Subject: Y/15/21/DOC Yapton - 38 units

Please find below also detailed responses to your queries raised in your e-mail dated 9th of March to 'Planning responses' and Simon Davis – copy of which is attached to this email. For ease of cross-referencing I have kept the same numbering as per your e-mail with all other points considered to be closed now.

Job Title			
LAND AT STAKERS FARM, YAPTON			
Drawing Title			
EXTERNAL WORKS LAYOUT 38 UNIT SITE - SHEET 1 OF 3			
Client			
DANDARA LIMITED (SOUTHERN)			
Scale	Date	Designed	
1:250 @ A1	SEP 20	CL	
Drawn	Checked	Approved	
JK	AK	SW	
Job No	Drawing No	Rev	
19-156	YAP-150-071	T3

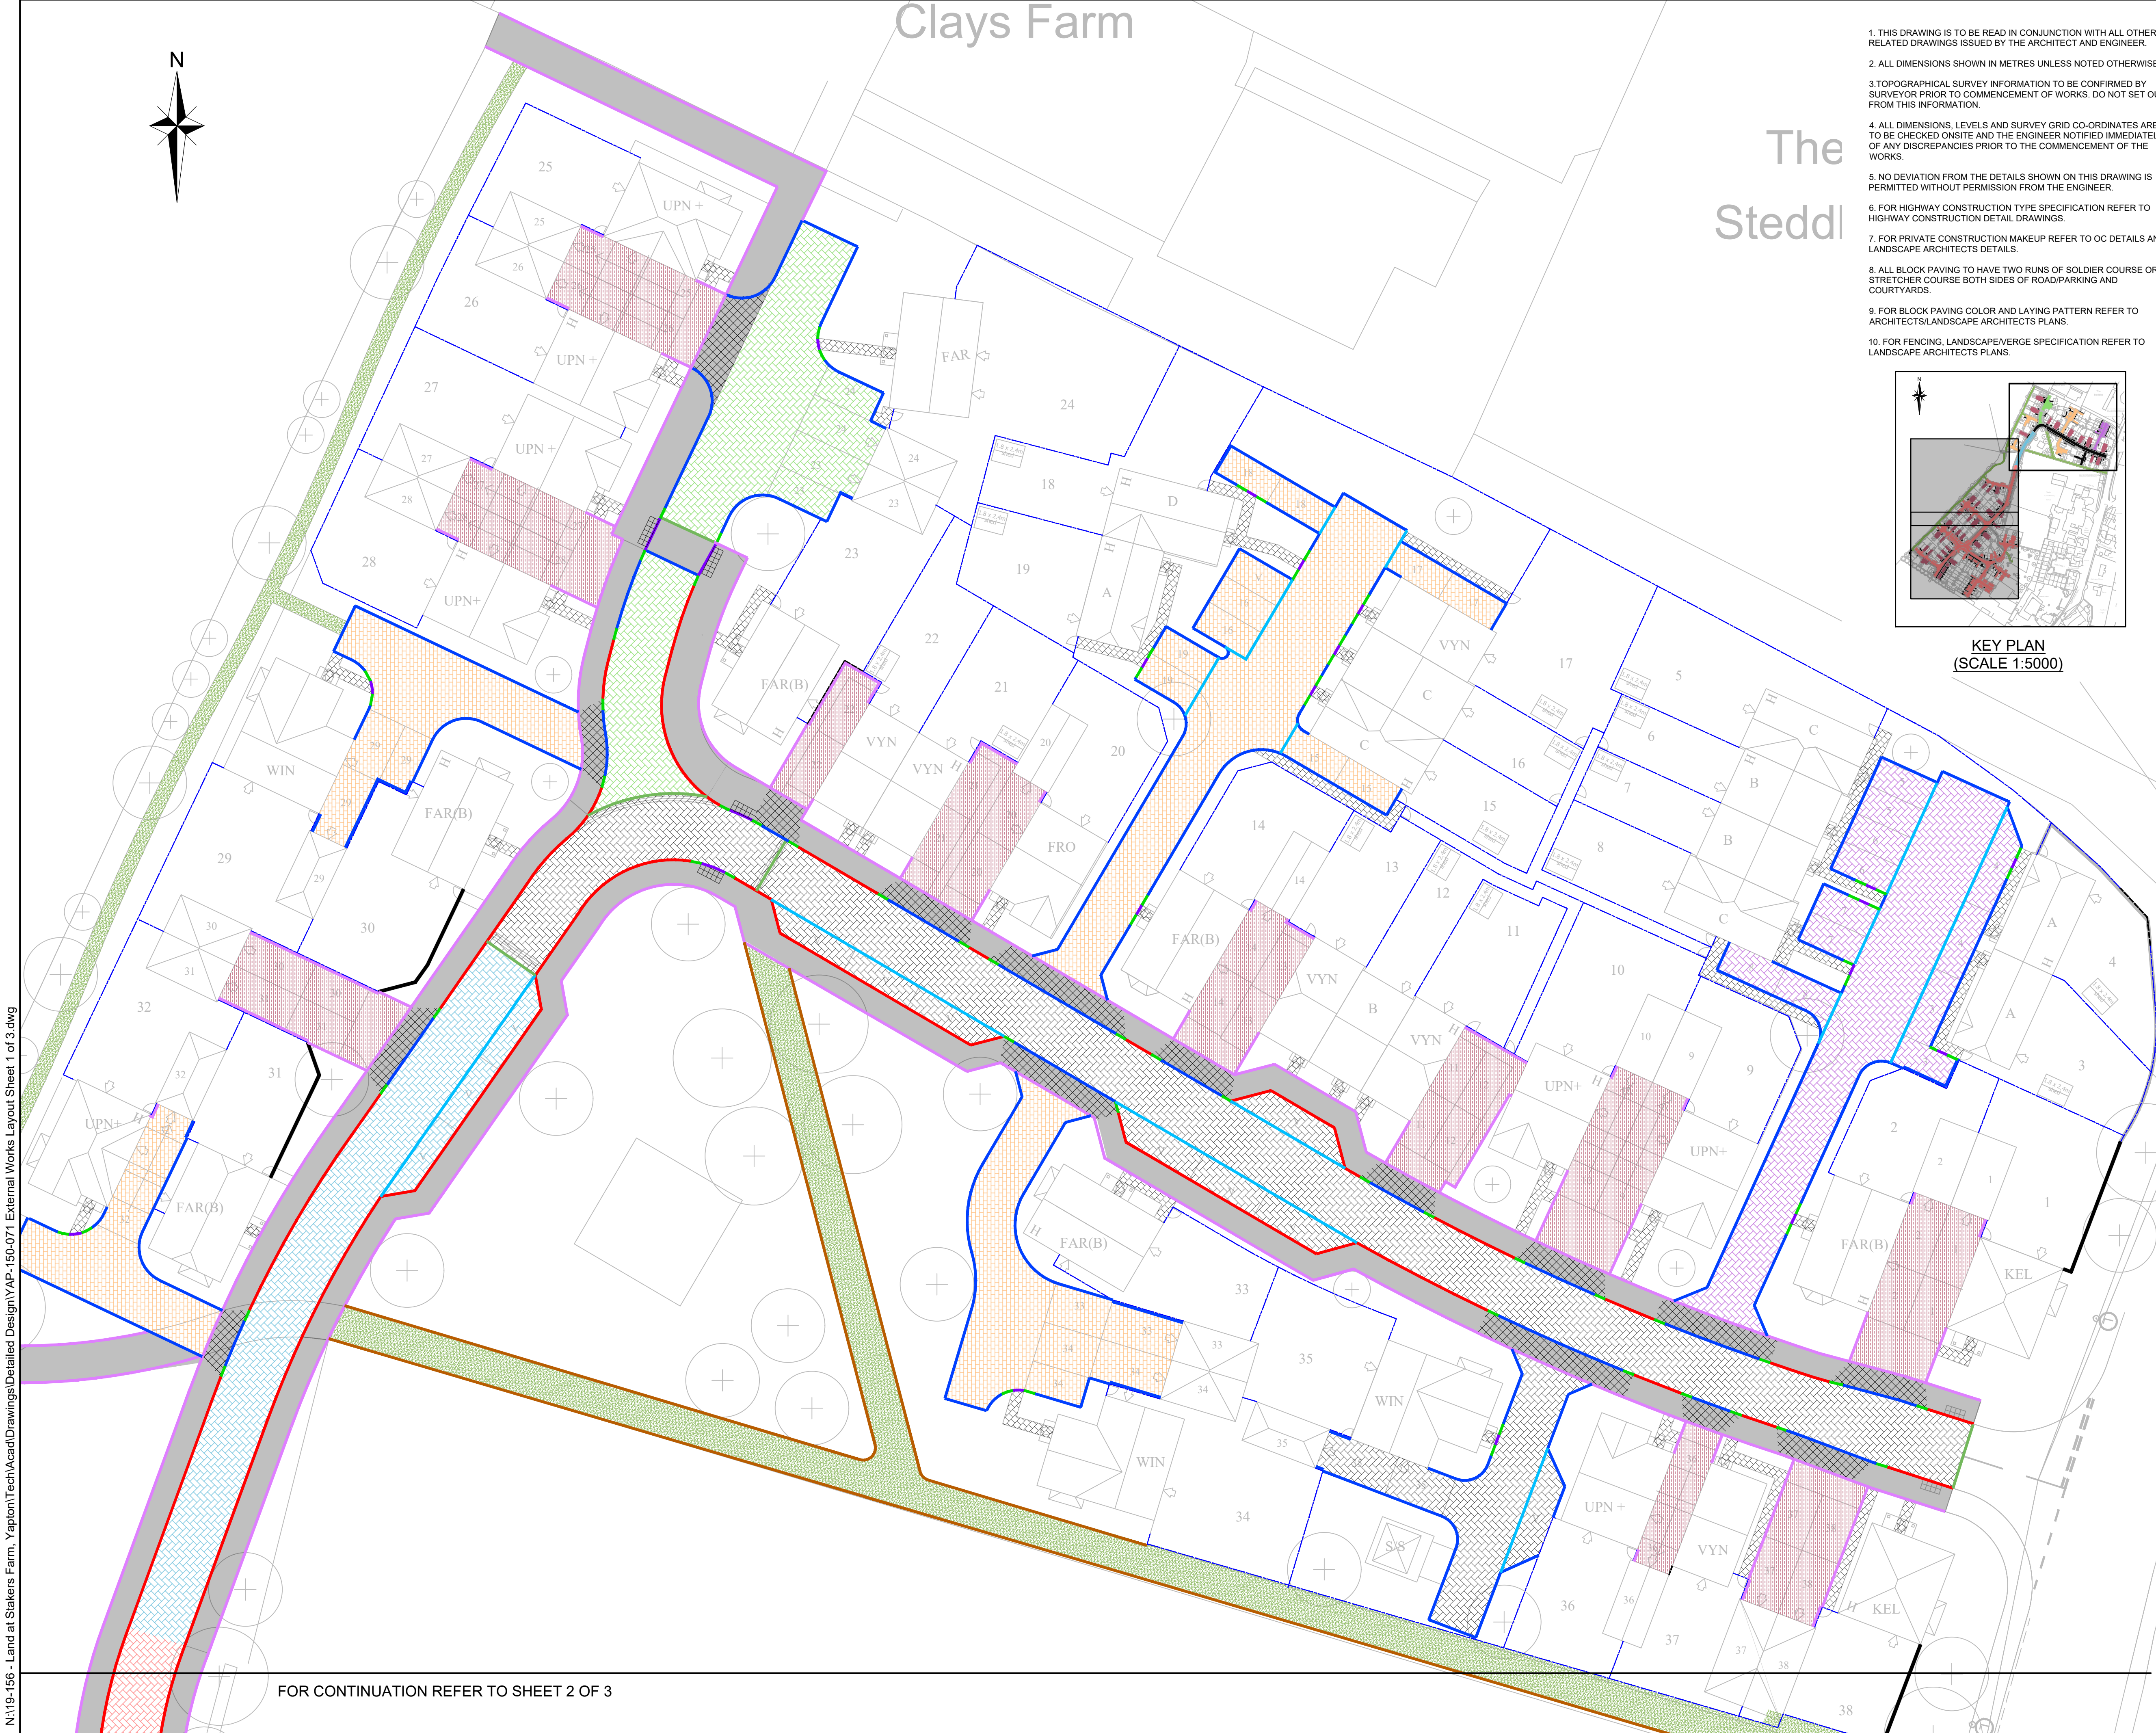
14. Sewerage undertaker satisfied with the proposals – please refer to the S104 compliance letter.
15. Road 3 will have increased sub-base material (as per construction detail for Road 3 on drawing YAP-180-035C2 Highway Construction Details Sheet 1 of 2) that will extend 2m beyond kerbline as indicated by hatched area on the YAP-130-028C1 Pervious System Network Layout_38 Units drawing. This is modelled as additional permeable paving sub-base at the same level as Permavoid crates (and is added to help with the half-drain times), with the actual pavement sub-base modelled on top of Permavoid. Additionally external works layout drawing YAP-150-071C1 and Pervious system network drawing YAP-130-028C1 clearly identify road type construction areas.

Job No	Drawing No	Rev
19-156	YAP-130-082	T3

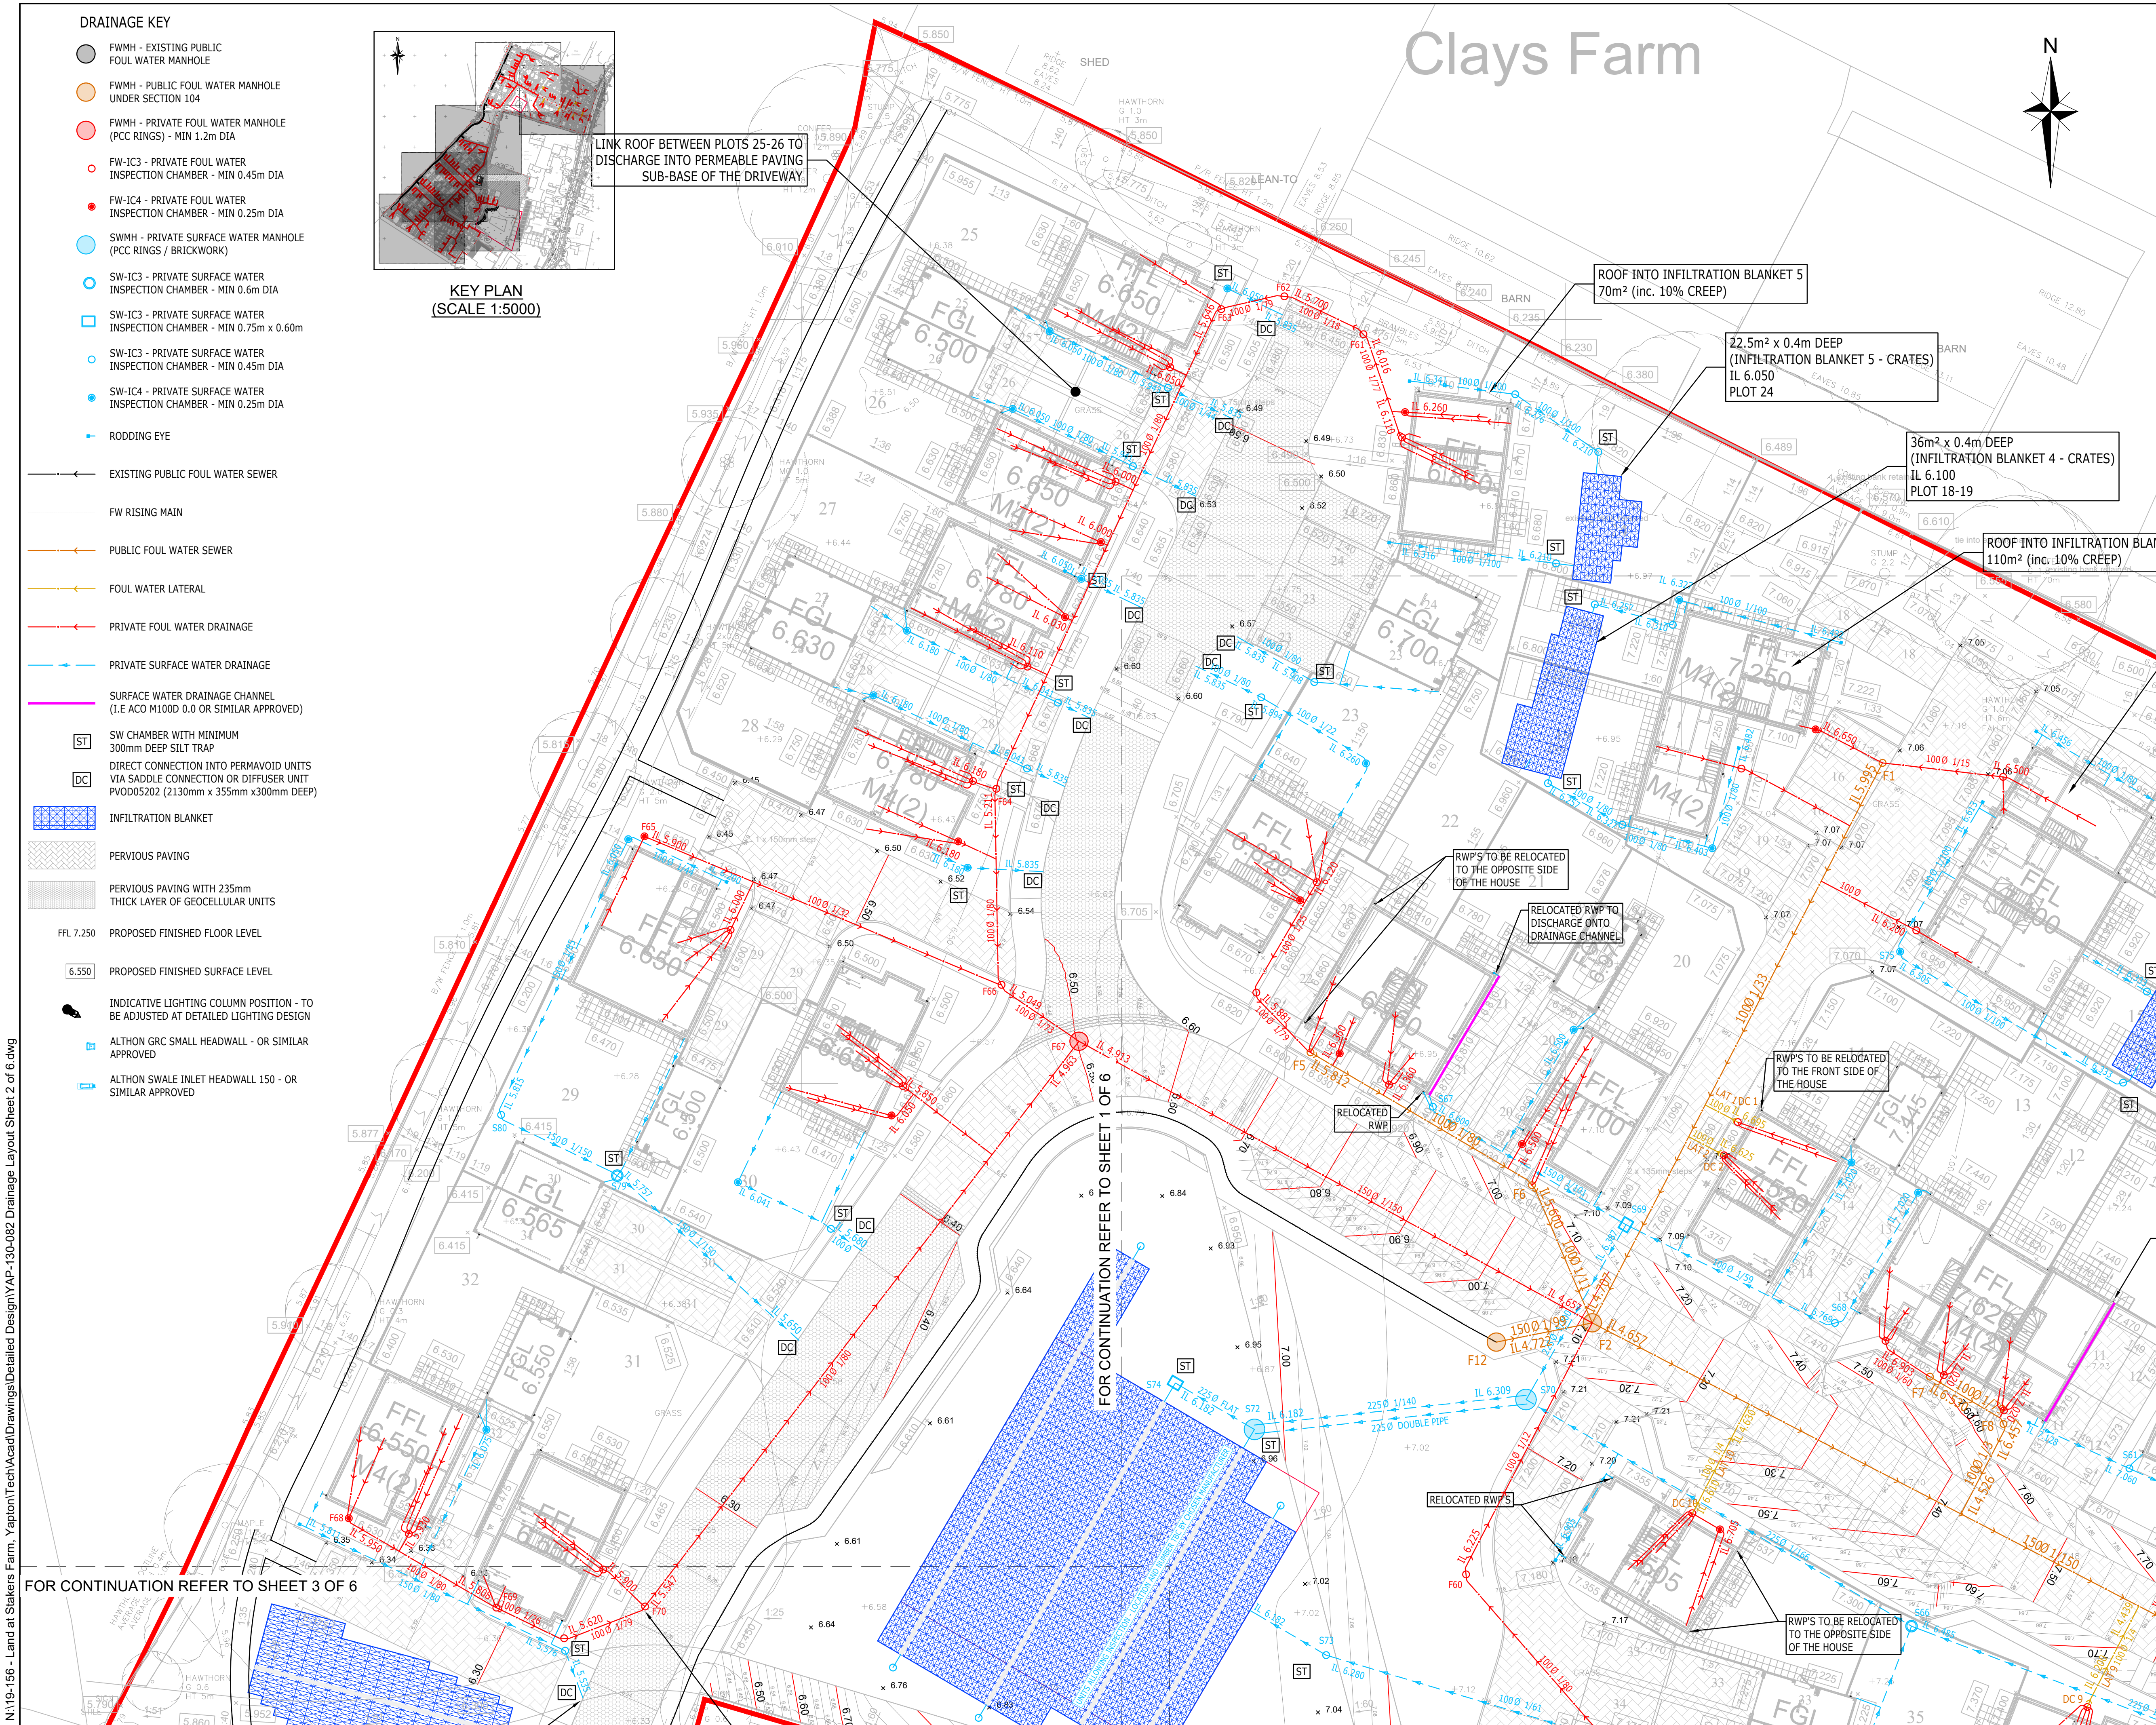
11. Alteration to the design undertaken. To comply with the LLFA SuDS Policy 1 point 5.2.2 the surface water (SW) system is designed so the last SW chamber (silt trap) is above the 1 in 10 years plus cc water level within permeable paving system. SW system chambers for Road 2 are not therefore lower than 5.995m AOD, which is a water depth of 0.15m (please see Road 2 with plots 23,25-28_1 in 10 yrs with CC_Rev_B calculations) for the storm design event added to the permeable paving base level of 5.835m AOD. The same principle will apply to Road 3, in this instance the water depth for the 1 in 10 yrs plus cc event is 0.288m (please see Road 3 plus plots 29-32_1 in 10 yrs with CC_Rev_C calculations) and with permeable paving sub-base level of 5.430m AOD (measured at the downstream end of Road 3, please see drawing YAP-130-028C1) results in the design water level of 5.718m AOD. We have designed last SW chamber (silt trap) prior to Permavoid connection to be not lower than this level and downstream pipe do not have any additional connection thus serves as connection conduit only with the actual SW system not being subjected to surcharge during the 1 in 10 yrs plus cc event. However, due to the use of proprietary connection fittings it is required to make connection directly to the Permavoid units, i.e. at the base of permeable paving - please see drawings YAP-130-082C3 and YAP-180-031C2.
